Your ref 3/2020/0159
Our ref 2nd April 2020
Date

Dear Sir
Application: 3/2020/0159
Application Site: Ribblesdale View Chatburn
Proposal: Discharge of Conditions

Landscaping Scheme

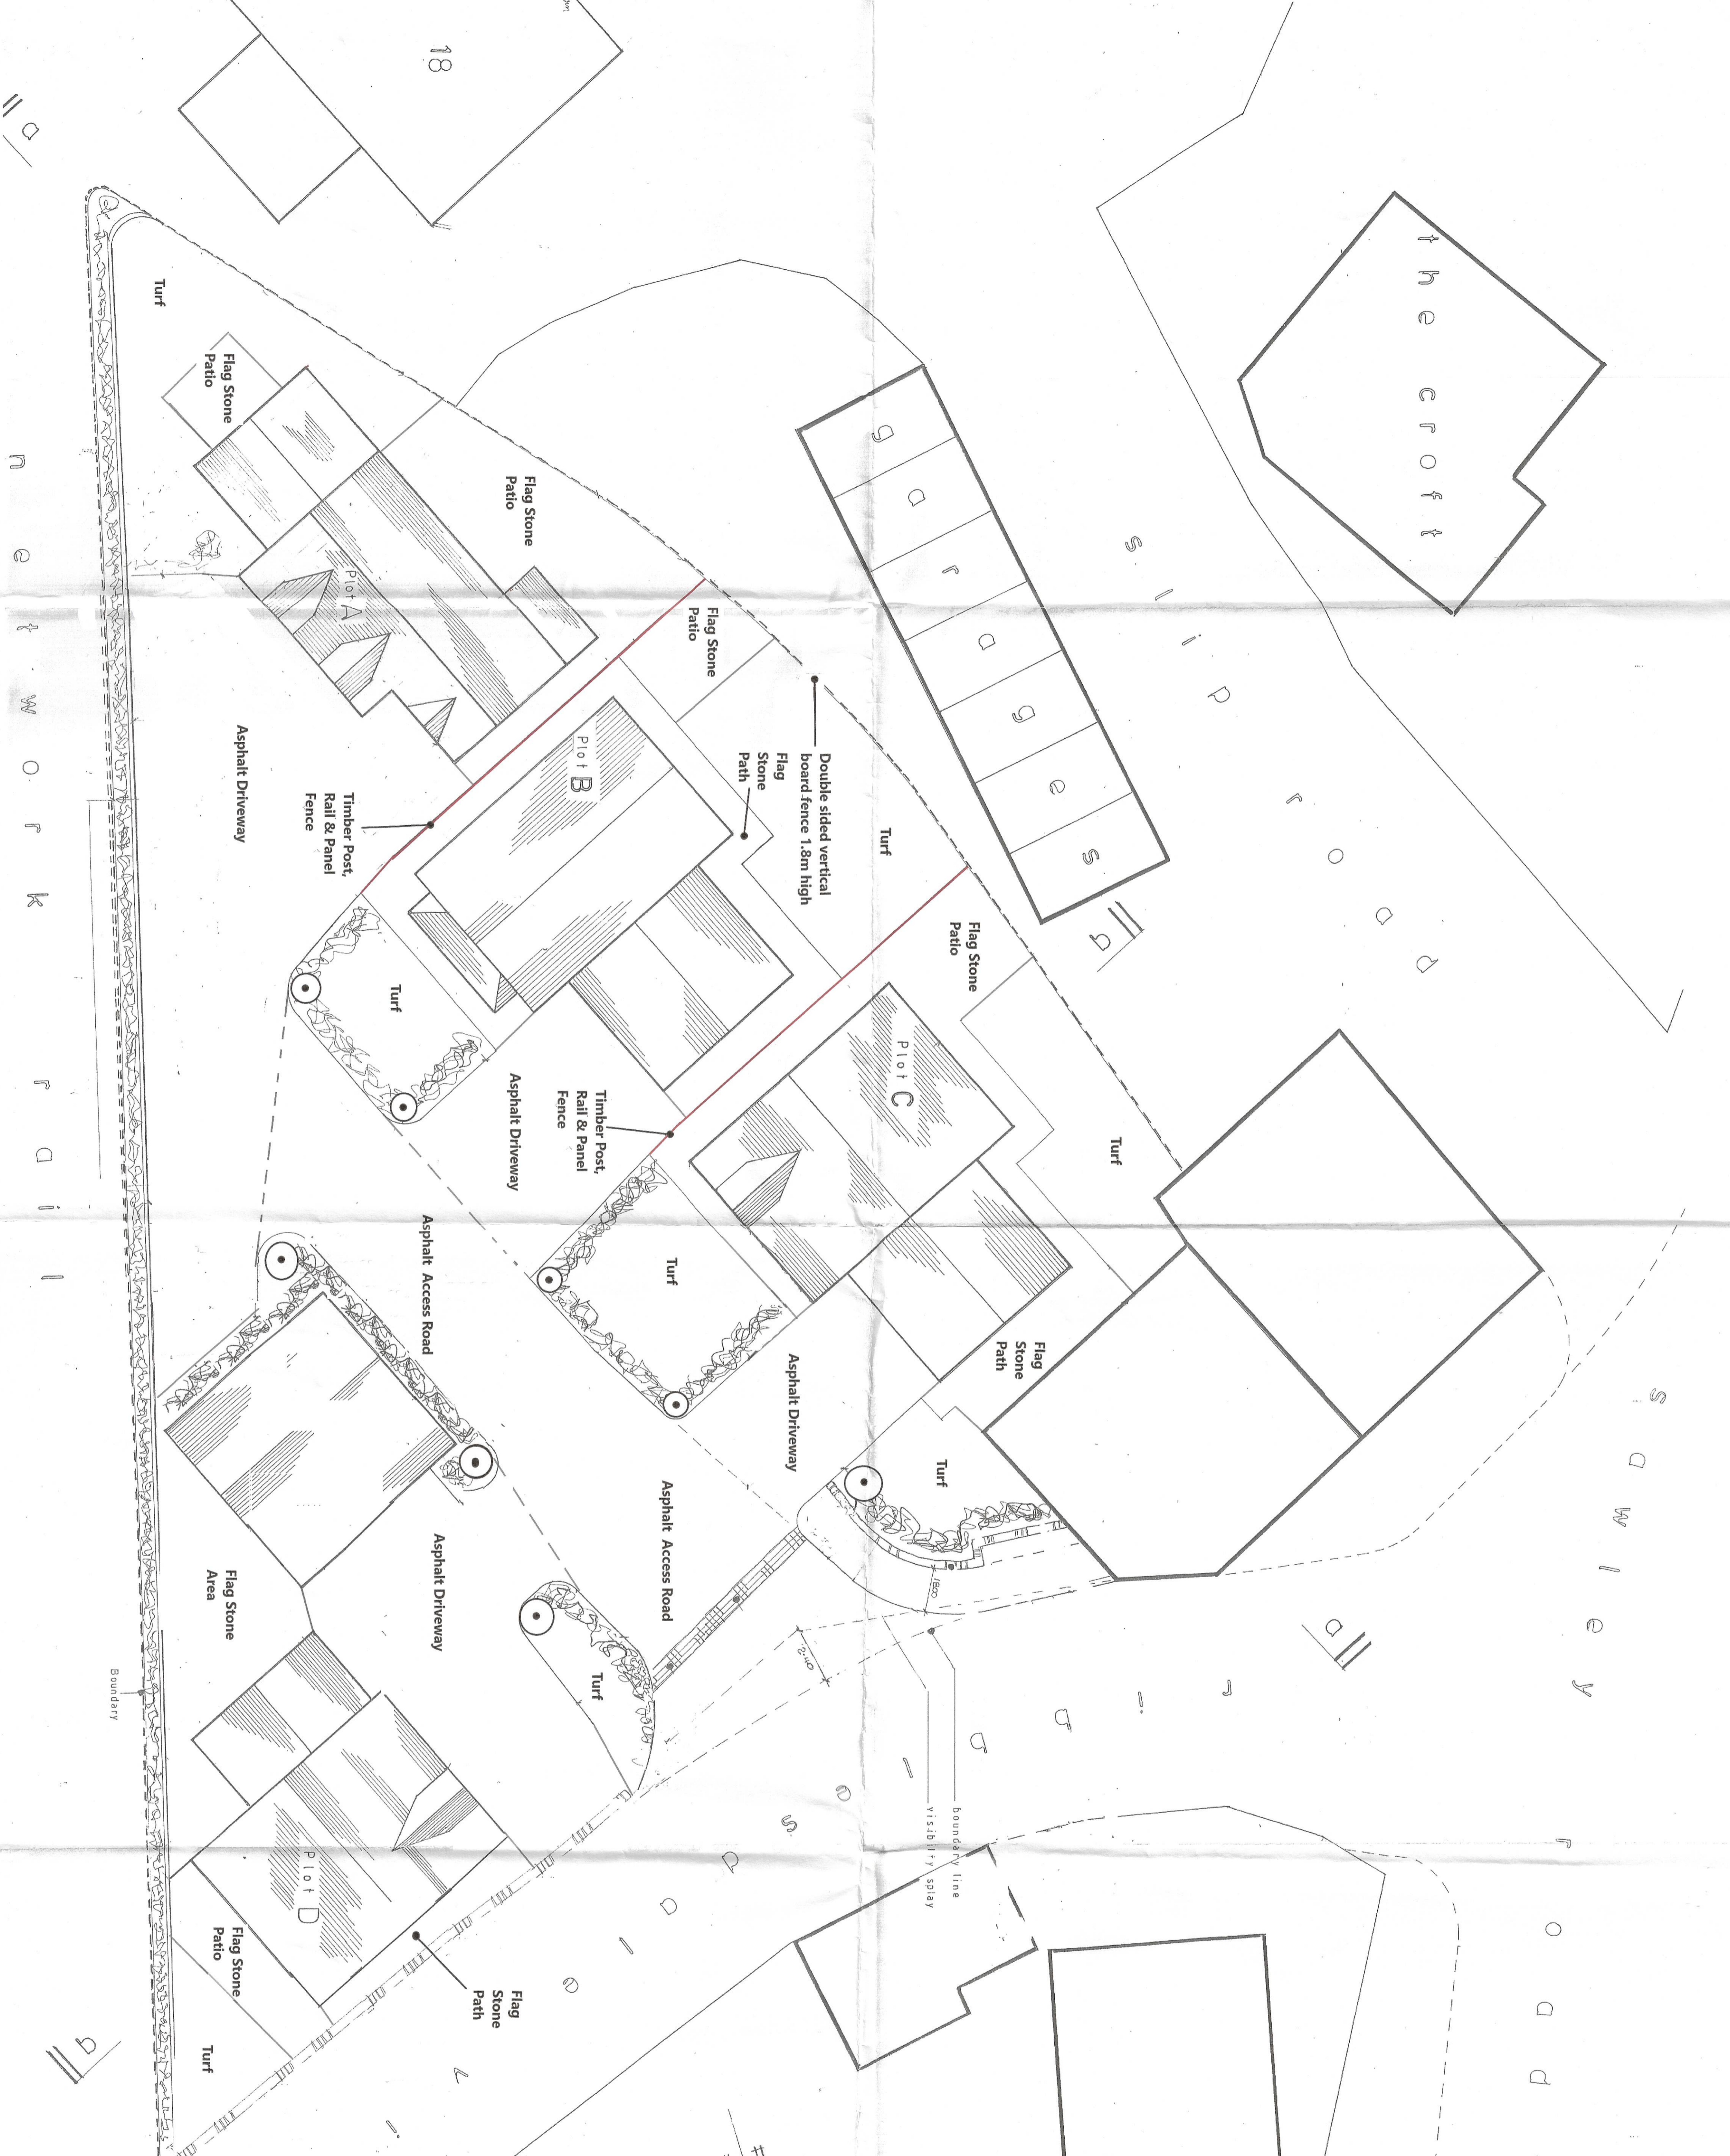
The proposals are acceptable and I would therefore raise no objection to the proposal on highway grounds. However the applicant proposes to replace the proposed grass treatment in the residual verge fronting the boundary wall with concrete, the preference of the highway authority would be for this area to be surfaced with tarmac
